MIAG and Mcl PC written submissions from oral presentation;

Issue Specific Hearings;

28th February, 2023 (am);

Noise

**FIGURE 15.1**

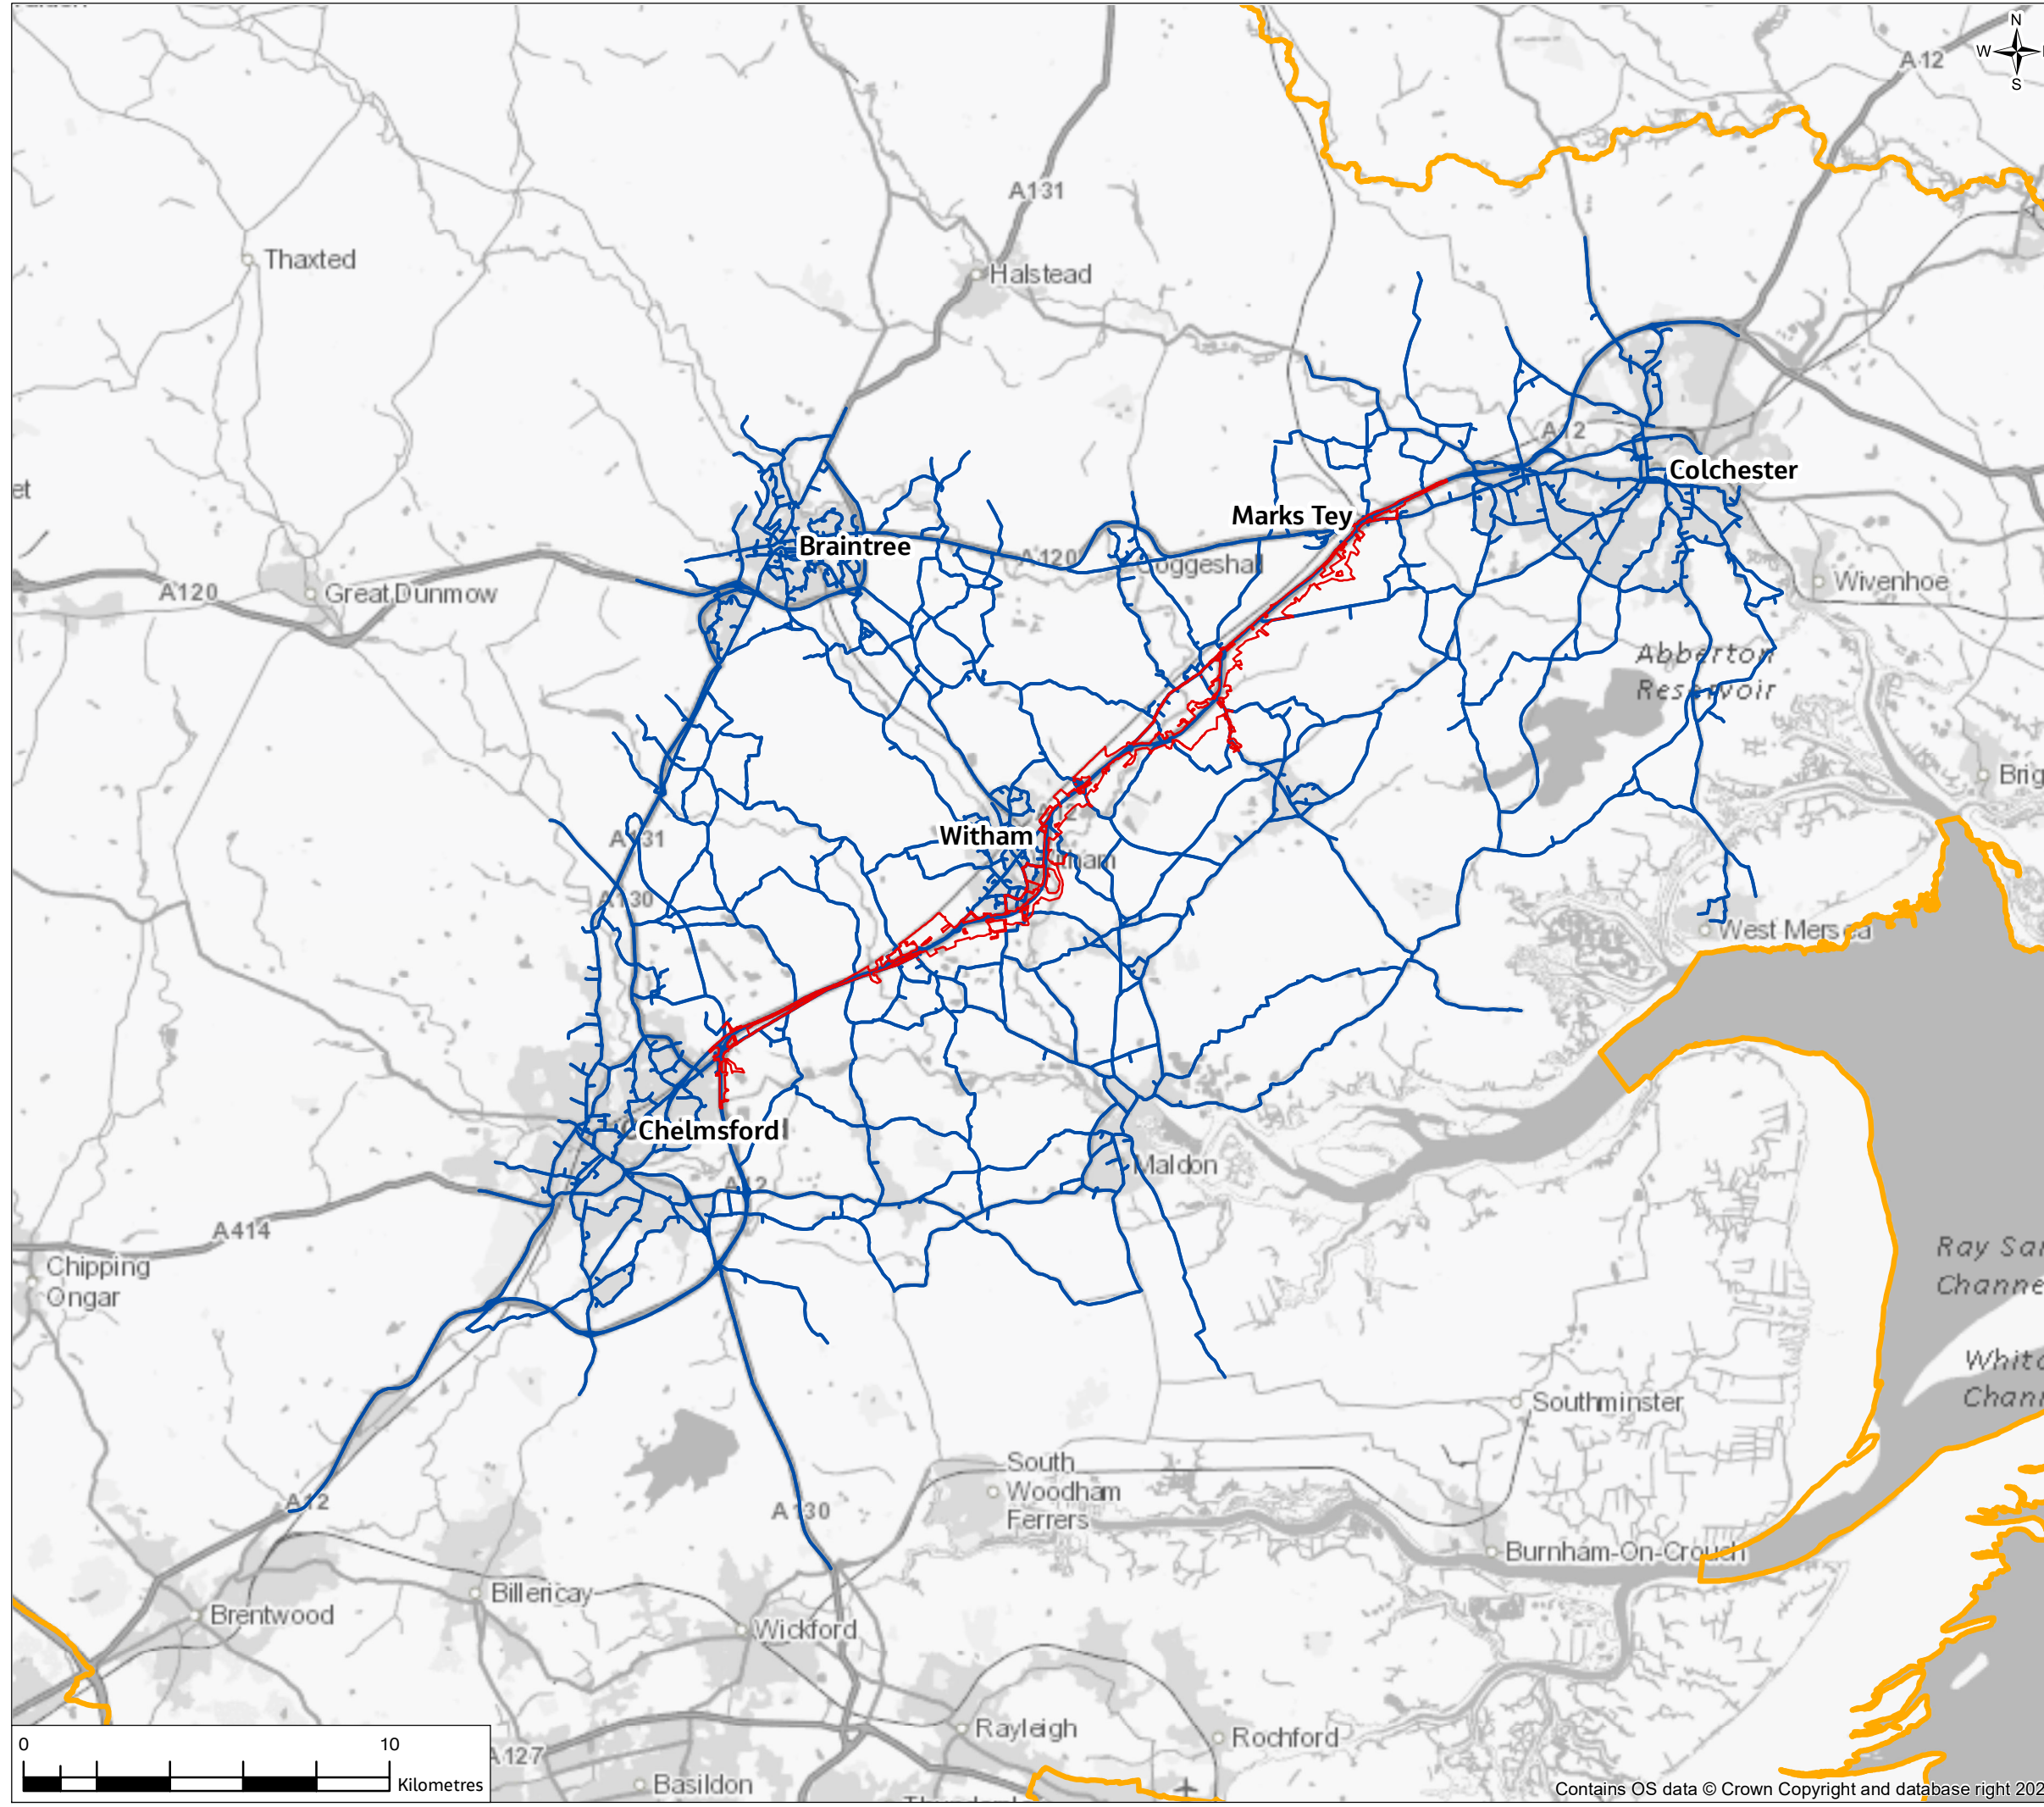
In Messing the expert said that although the village was outside the 1.6km buffer some testing had been done. None of vibration as that was not accepted by NH as necessary.

Despite requests for a more appropriate solution to this known likely outcome, NH remain minded to cite as their defence the 1.6km buffer and completely fail to recognise the collateral damage outside that buffer of their plan.

From the junction of Kelvedon Road with Inworth Road the measurements are:

1.63 km to the edge of the cemetery at the entrance to the village (opposite School Road);

1.83 km to the centre of the cemetery in front of All Saints Church;

1.78 km to the War Memorial;

1.91 km to the front of The Old Crown.

This justification for not investigating the destruction of the village of Messing and the SOAEL levels reaching severe on 71 houses, is therefore based on the difference of just 3m to the village boundary, and 31m to the heart of the Conservation area.
